January 17, 2022

Re: Agency Review Comments

We are in receipt of your review letter dated October 21, 2021. Below is a point-by-point response to the unresolved comments prepared in coordination with the (Developer) and Design Team.

**APISHAPA HEIGHTS - W/ GARAGE TYPICAL SECTION - 1
(PRIVATE DRIVEWAY)**

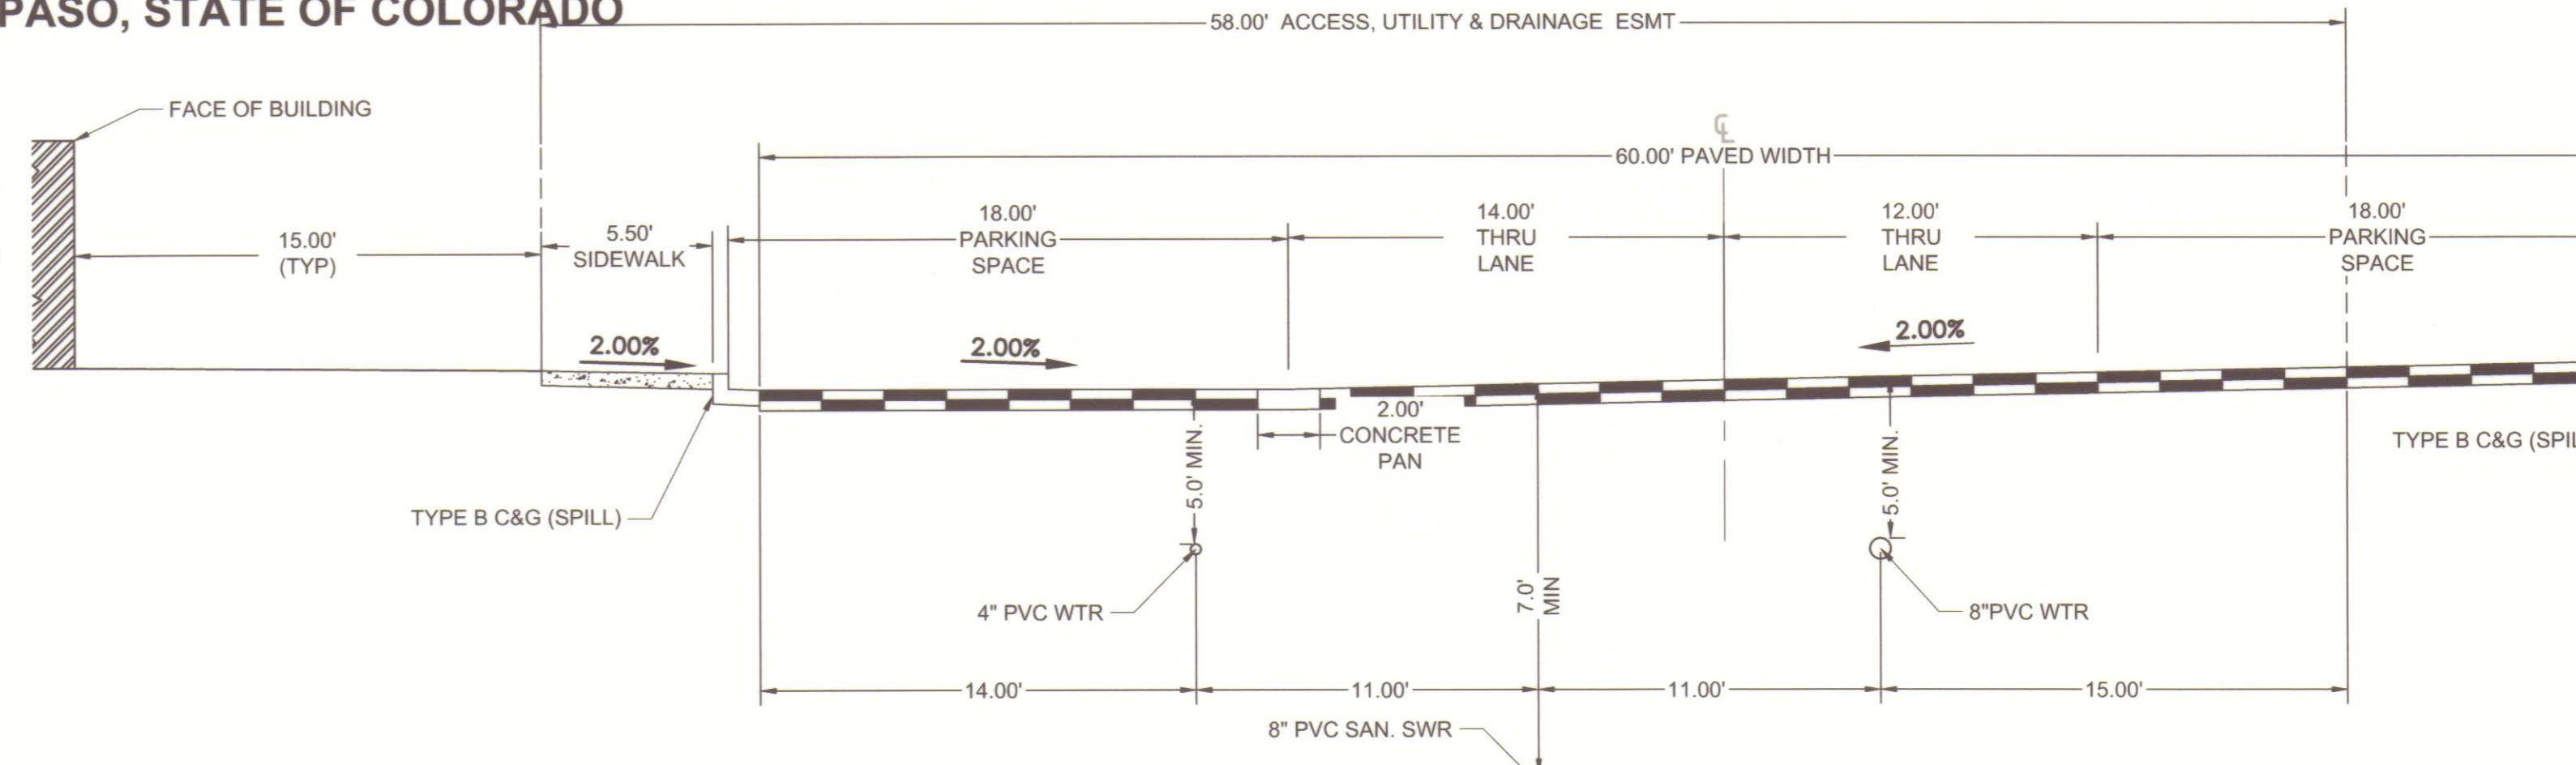
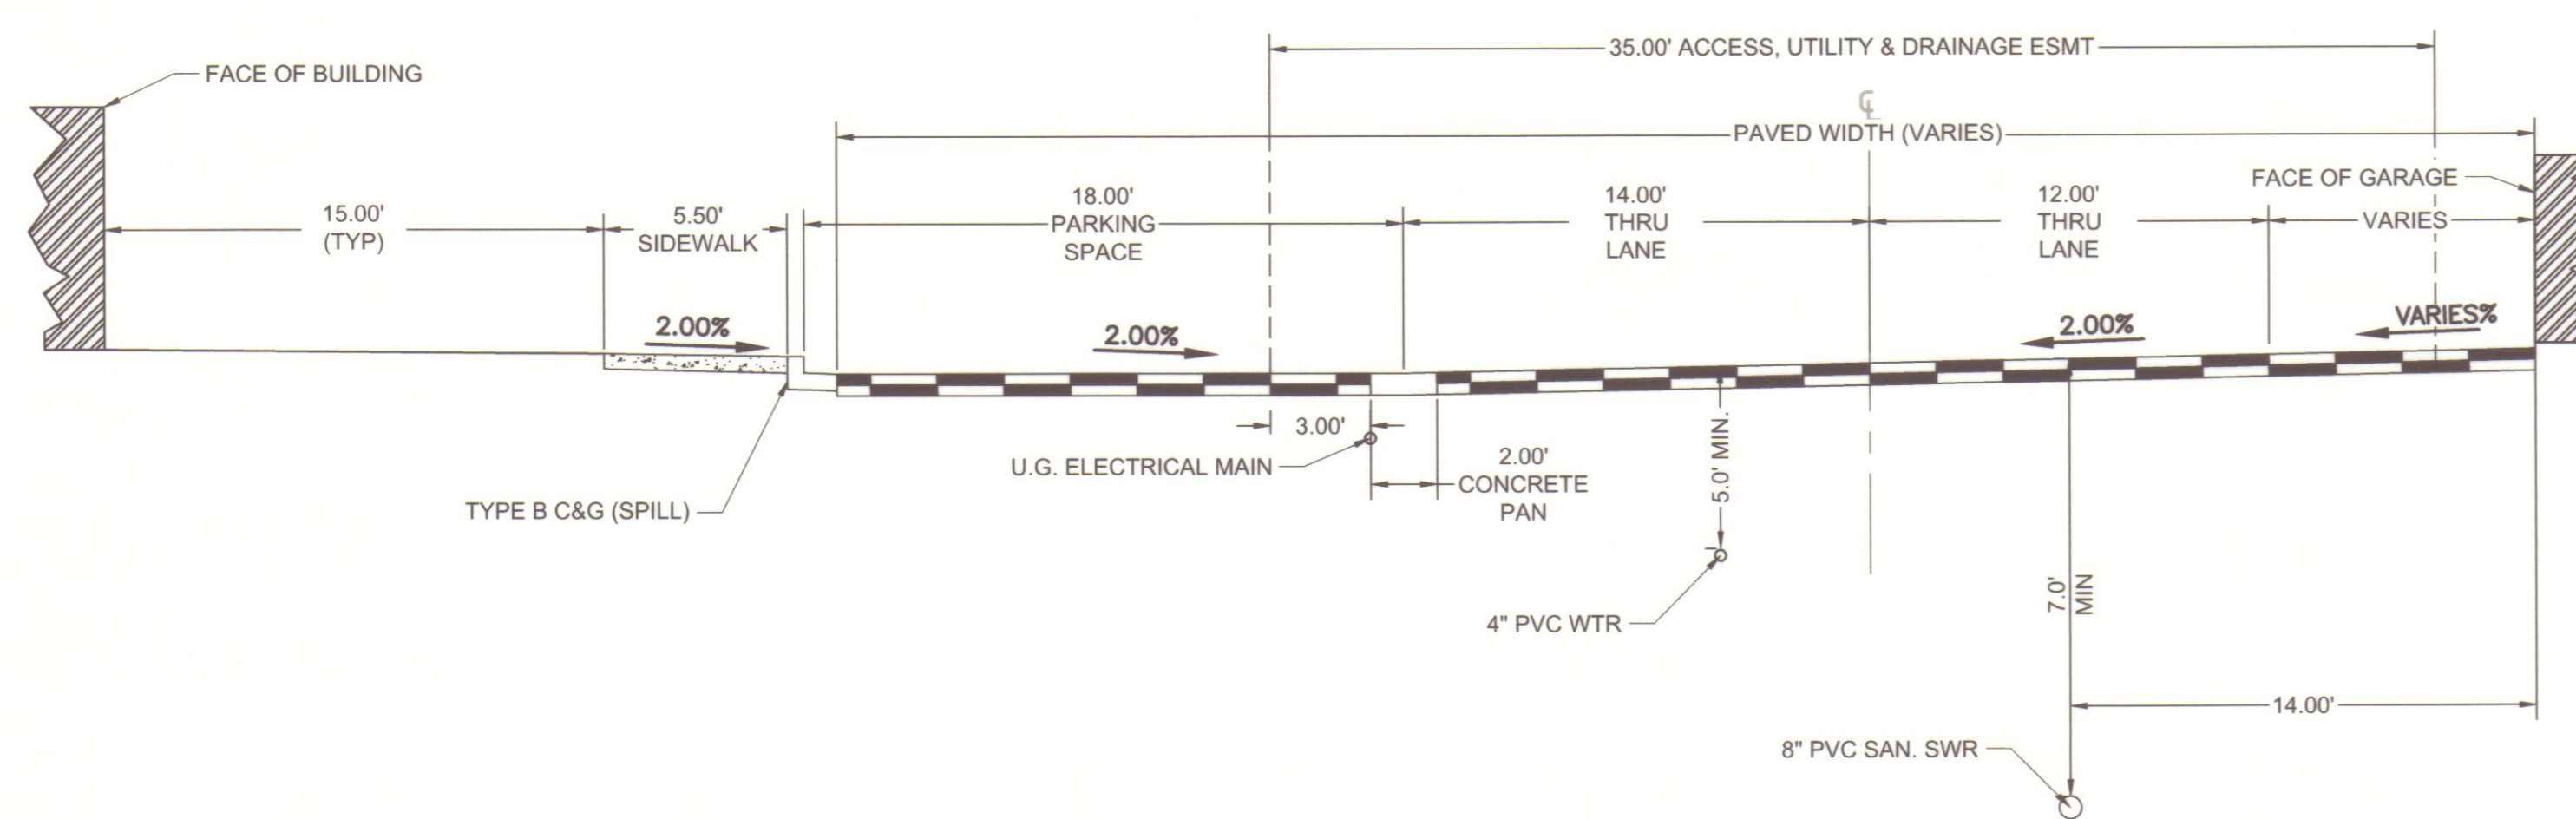
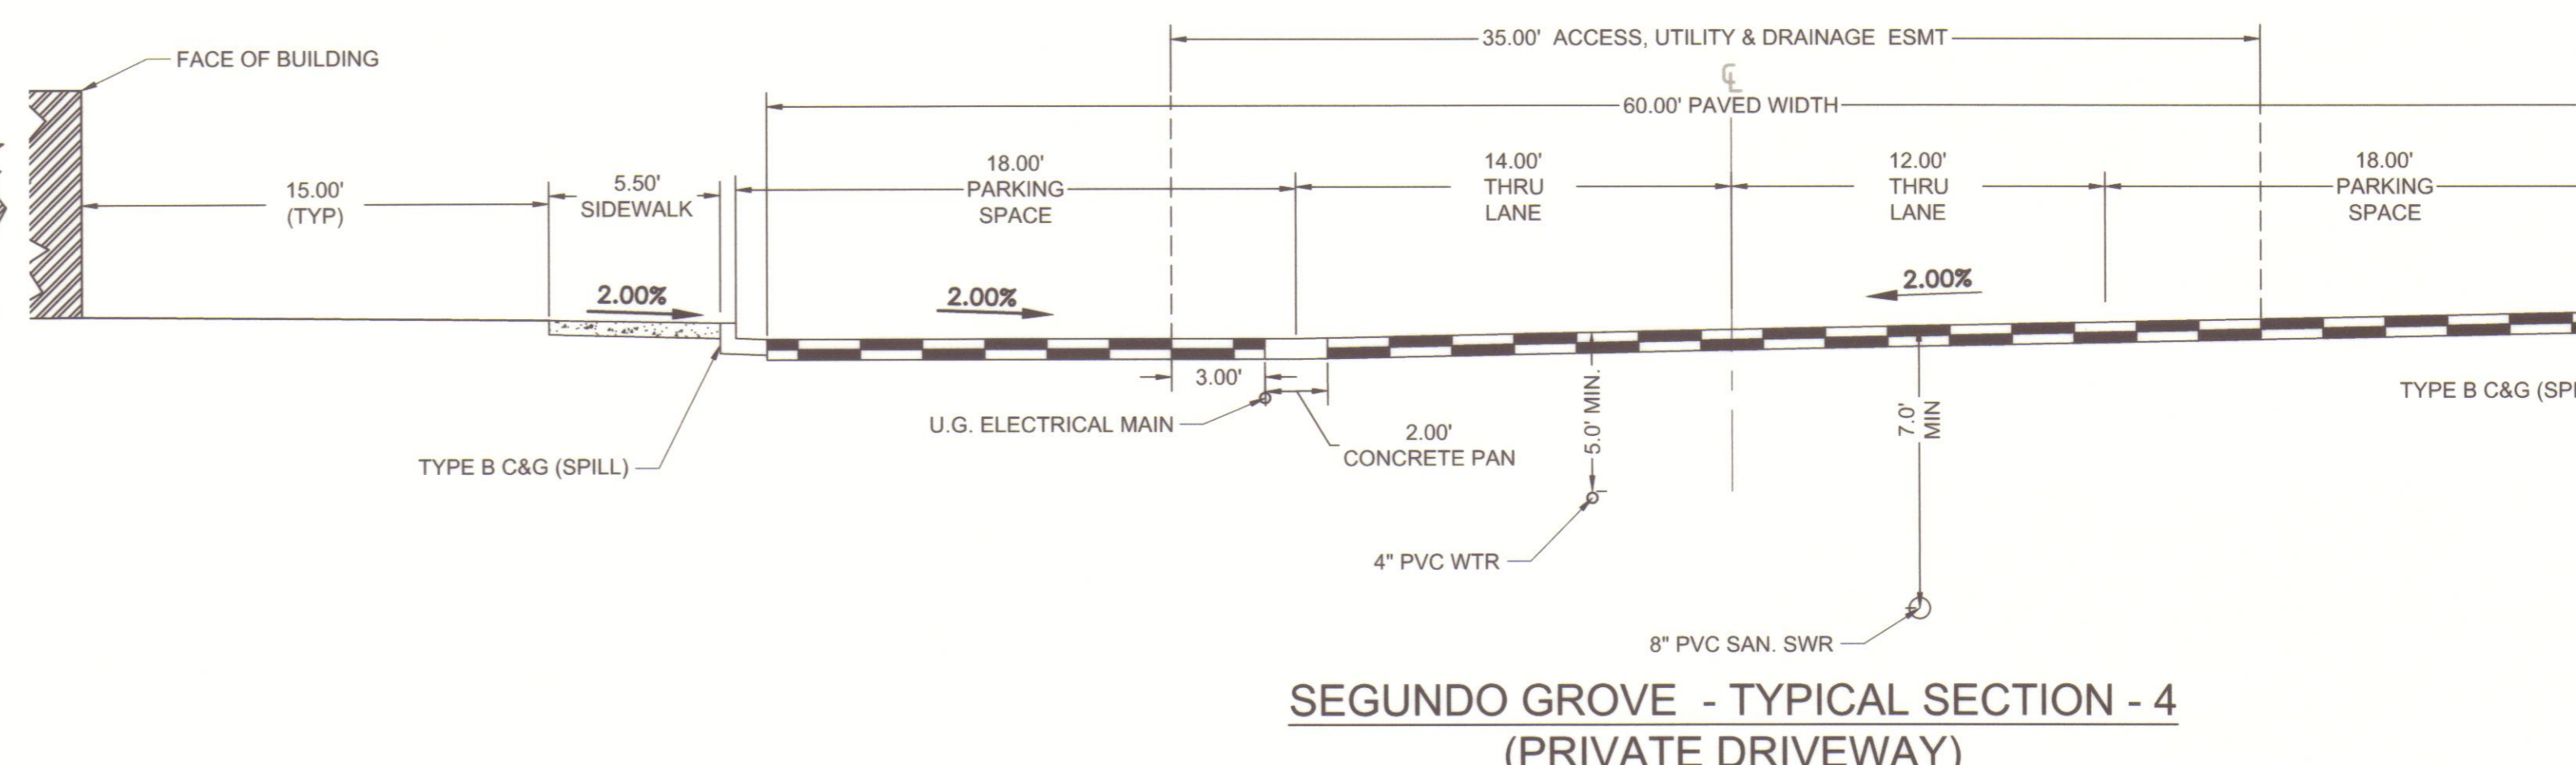
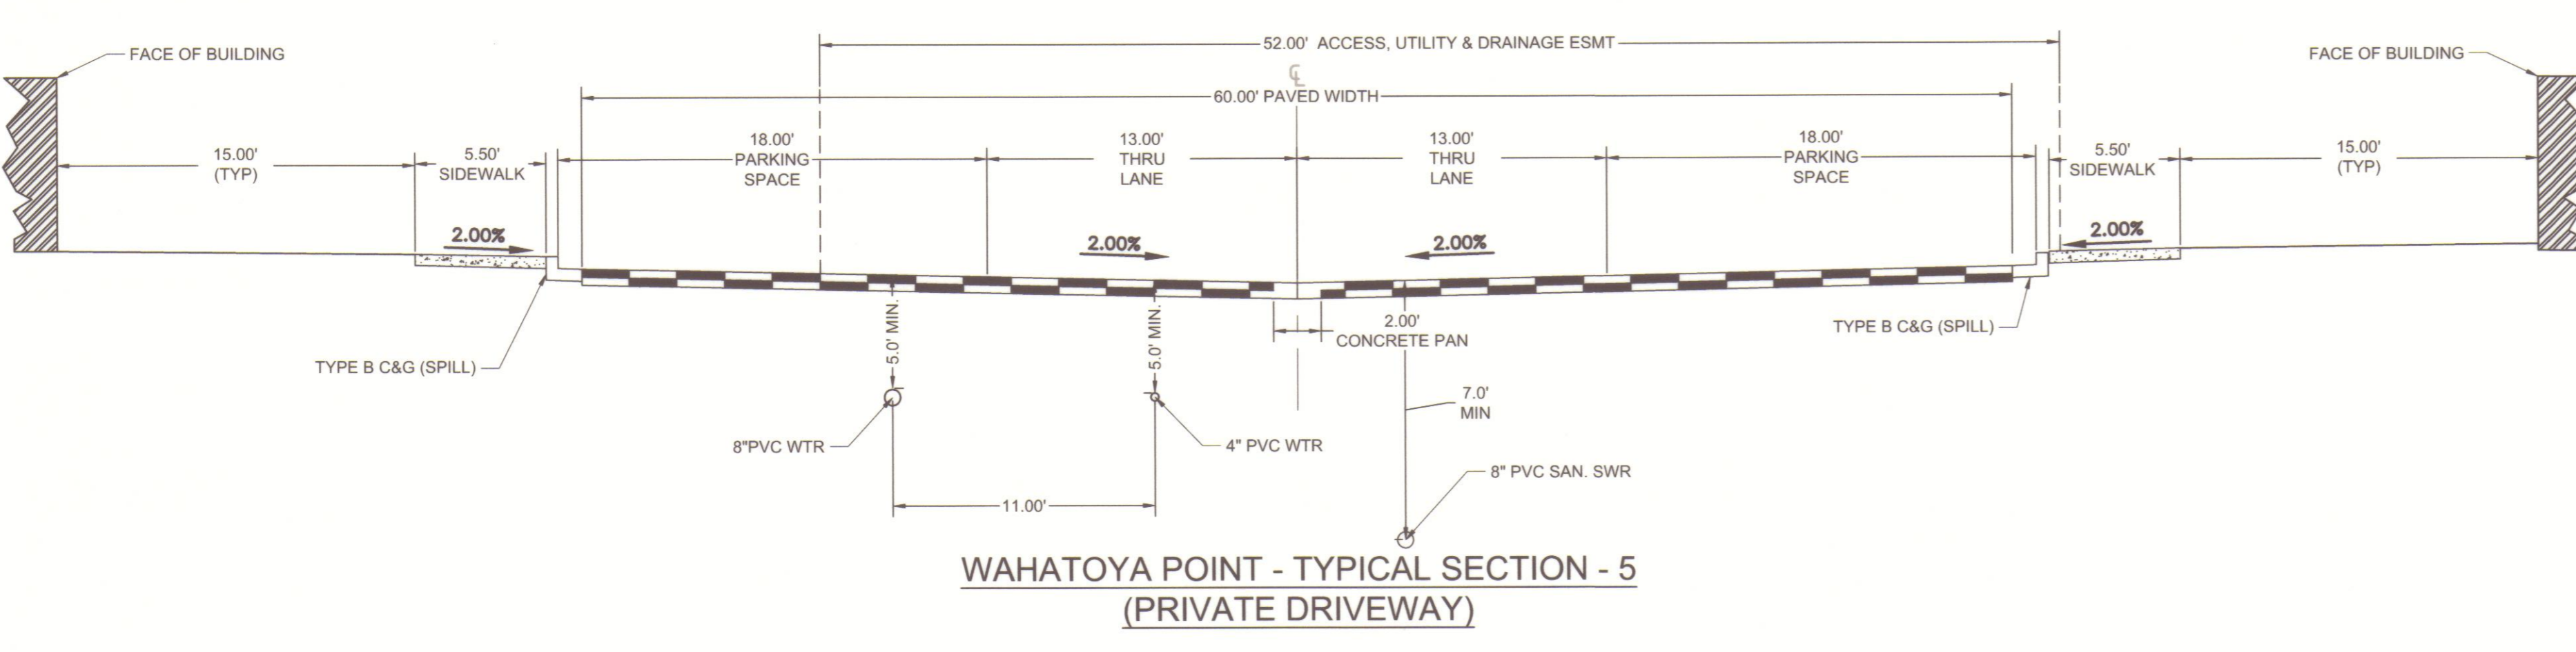
**HR Green Response: Unit numbers added to plan.**
3. It appears at least three street names are needed, provide a list of proposed street names to Justin Annan [jannan@elpasoteller911.org](mailto:jannan@elpasoteller911.org), and Glen West [gwest@elpasotellerp11.org](mailto:gwest@elpasotellerp11.org) with El Paso/Teller County 911 Authority. An email from E-911 showing street names is required for Enumeration approval. Once street names are approved, add to the development plan.

1. Roads depicted in the drawings are currently lacking names

**HR Green Response: Approved street names have been added to the Plans**
4. An amenity center was referenced in the letter of intent. Is this a structure? If this is a building, show location on approved development plan for addressing.

**HR Green Response: Approved private drive names have been added to plans.**
